May 16, 2019

Job No. 1396-001-016

Subject: Shoreline Substantial Development Permit Associated with the Vantage Bay PUD (File SD-18-00002; Z-06-00025; & LP-06-00026)
Response to Department of Ecology Comments

Figure 4. Wetland boundary and 100 and 150 foot buffers.

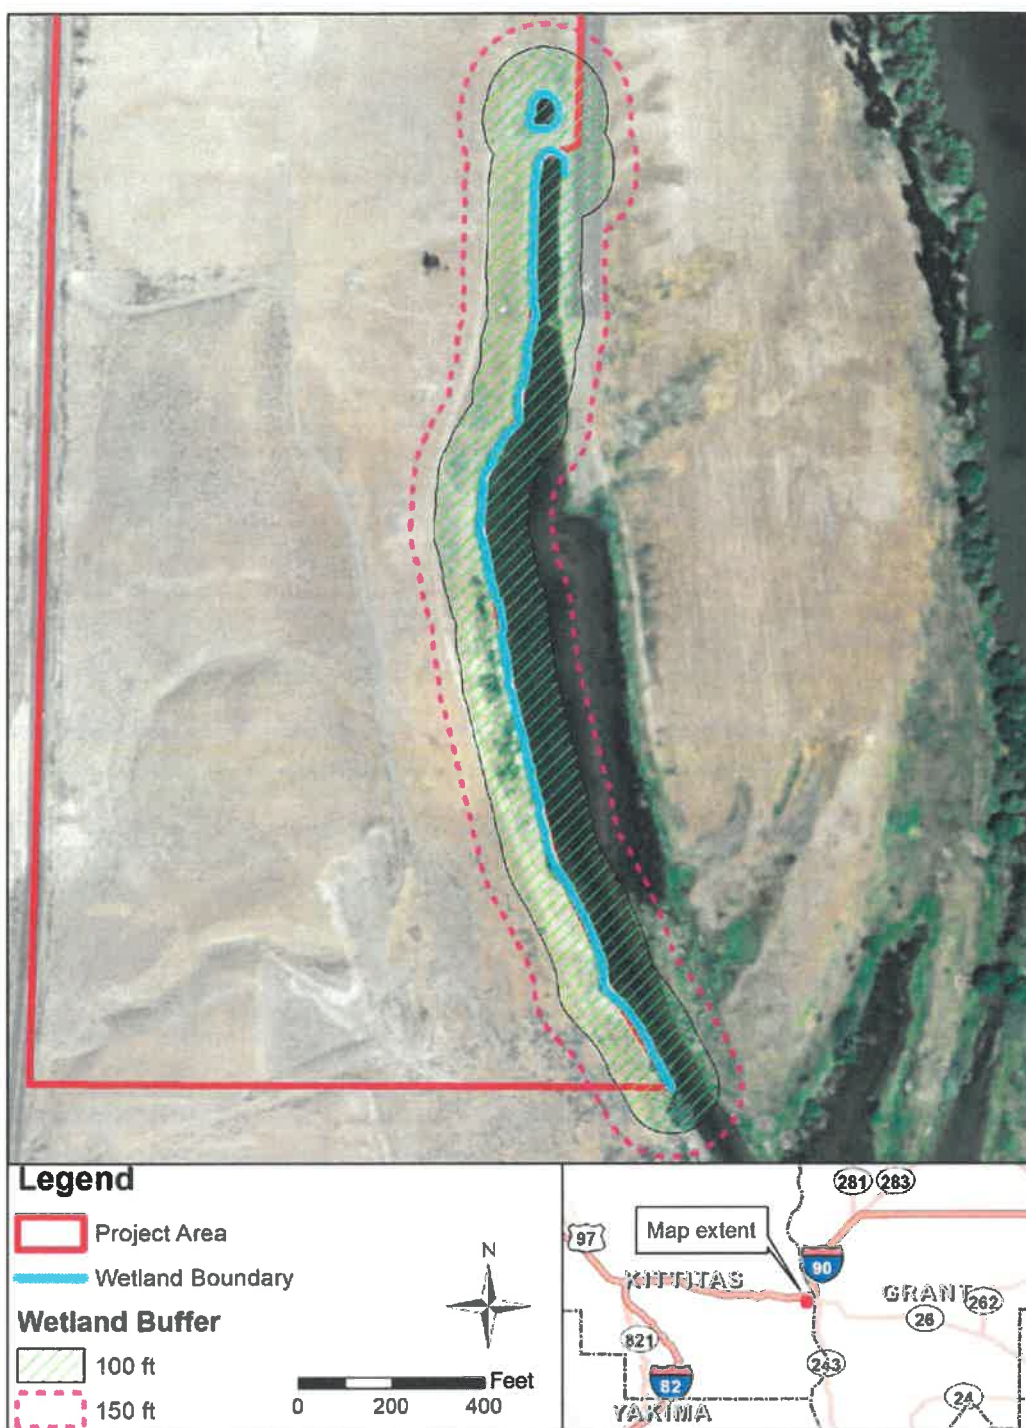
a. The category and precise location of the boundary of the wetland(s)	a. EAS delineated and rated a Category III wetland on April 18, 2019. The location of the wetland boundary is illustrated on the included site plan and on page 11 of EAS' report. EAS used a high-accuracy Trimble GeoXH GPS to record features in the field.

JOB NO.: 1396/001/014
 DWG. NAME: ST-01
 DESIGNED BY:
 DRAWN BY: CJR
 CHECKED BY:
 DATE: 12/12/2018
 DATE OF PRINT:
ST-01
 1 OF 4 SHEETS

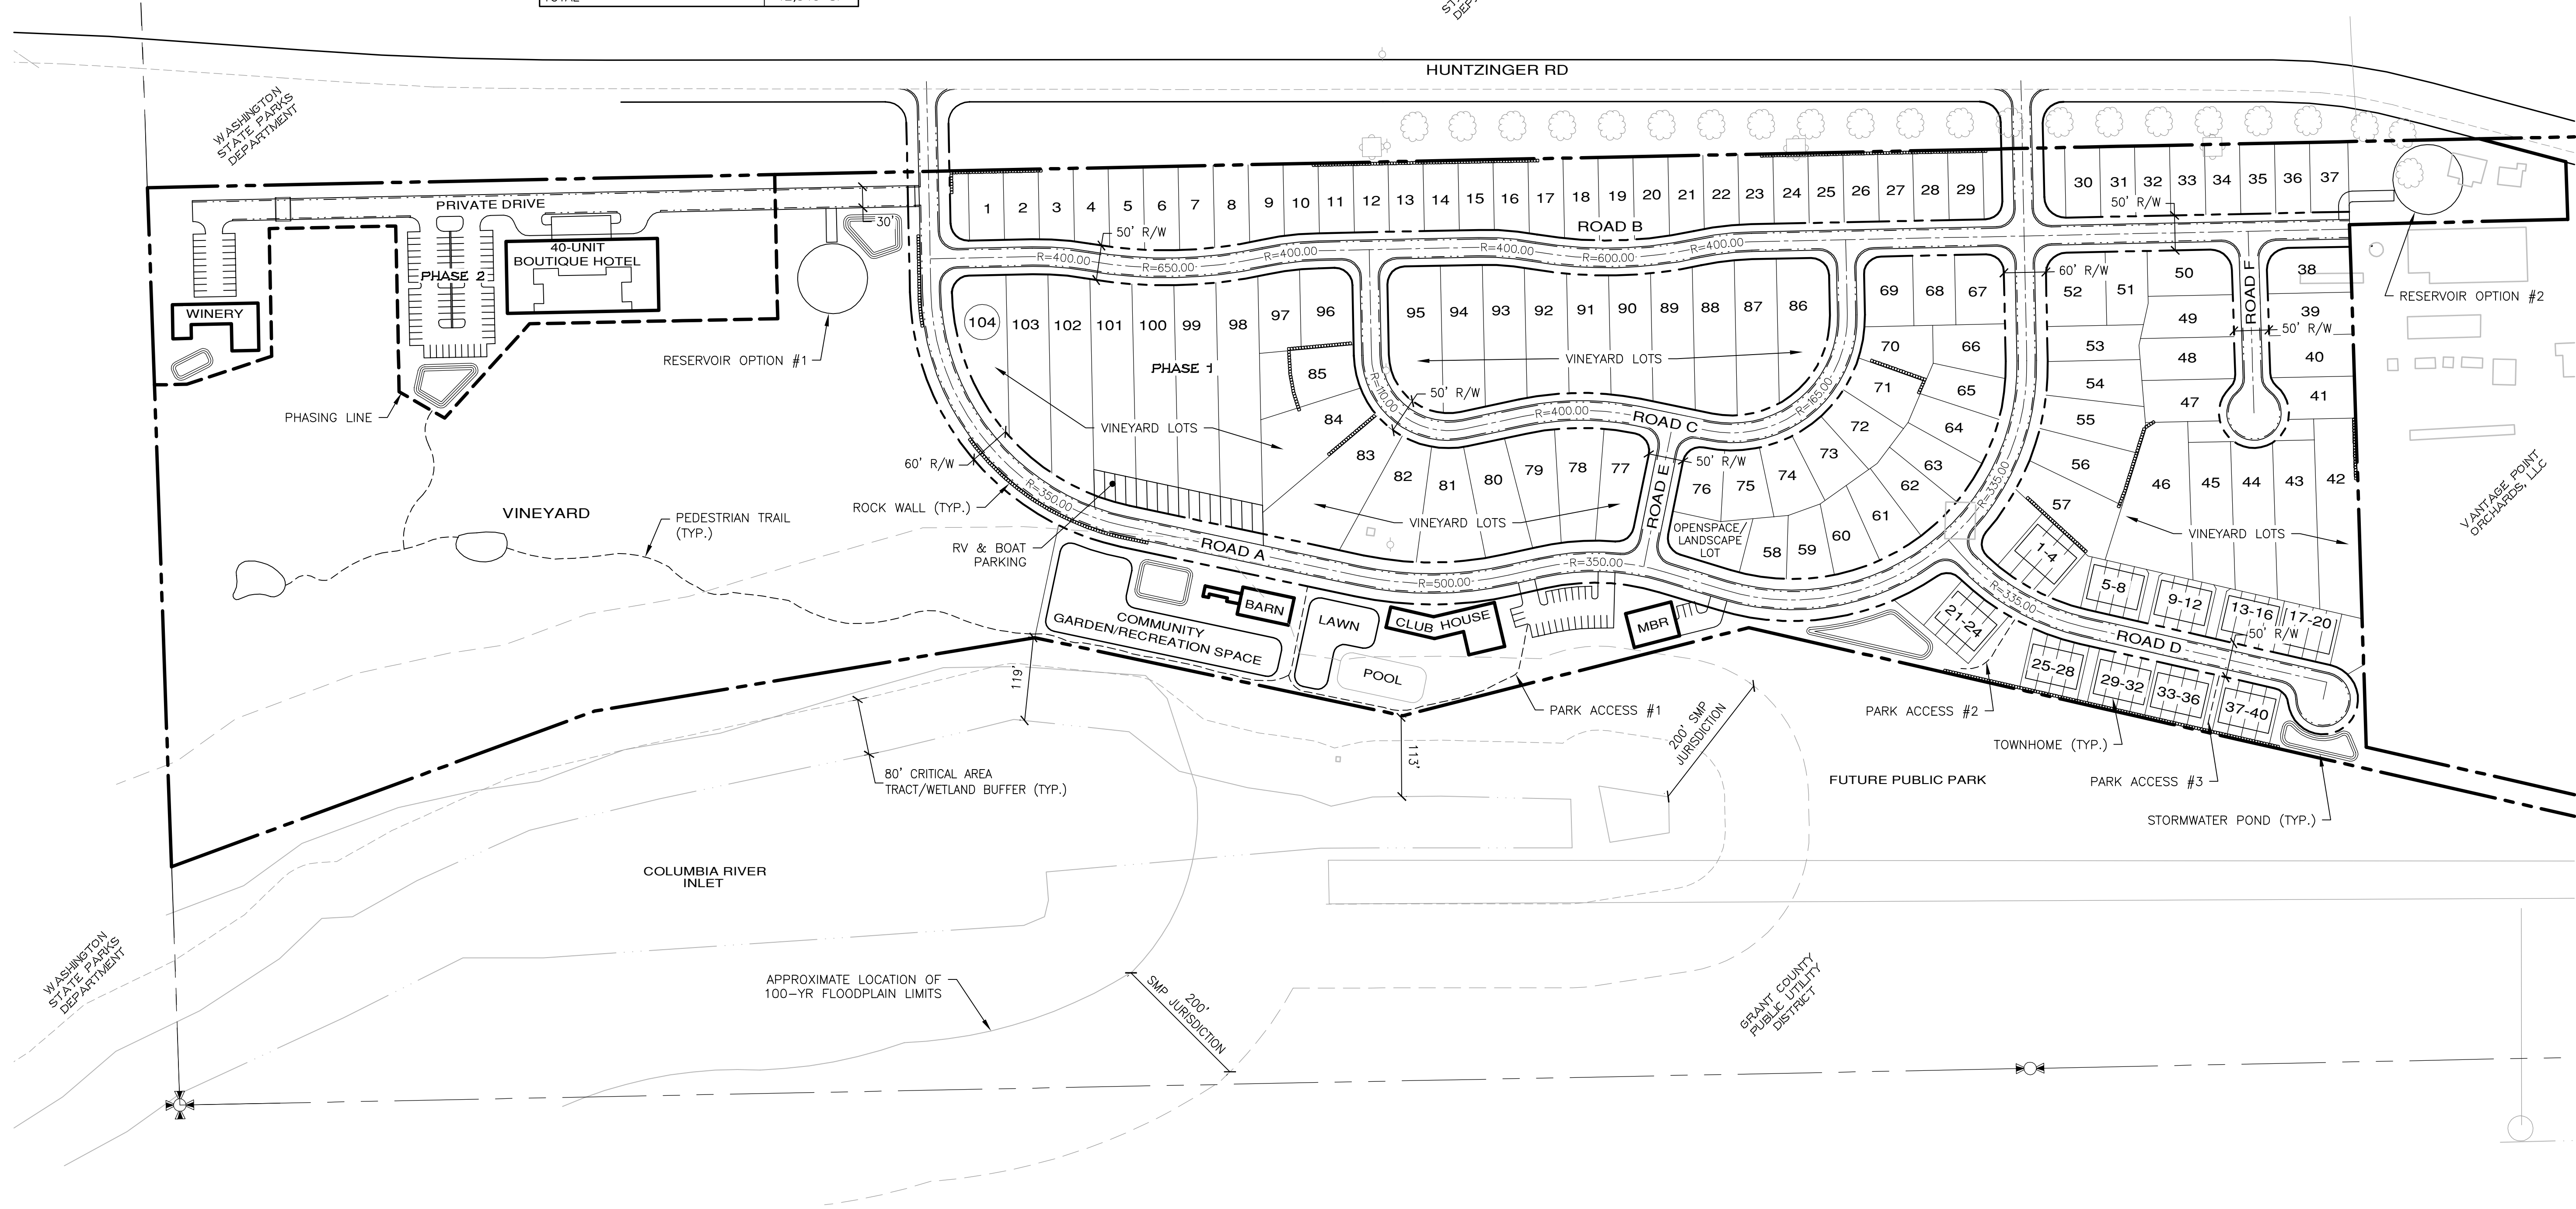
b. All wetlands and required buffers within three hundred (300) feet of the project area shall be depicted on the site plan. Best available information should include, but not be limited to, aerial photos, soils maps, and/or topographic maps; and	b. EAS reviewed the project site and areas surrounding the site. The included report demonstrates that EAS utilized best available information for preparing their wetland delineation report.

BCSCBN, Inc has taken care of minimizing impacts to existing critical areas on site as demonstrated in the revised site plan. Moving forward, we are looking forward to the County's review and conclusion that the proposed project satisfies the requirements outlined in the SMP, Kittitas County Code Title 17 and the conditions of approval found in Ordinance 2006-060.
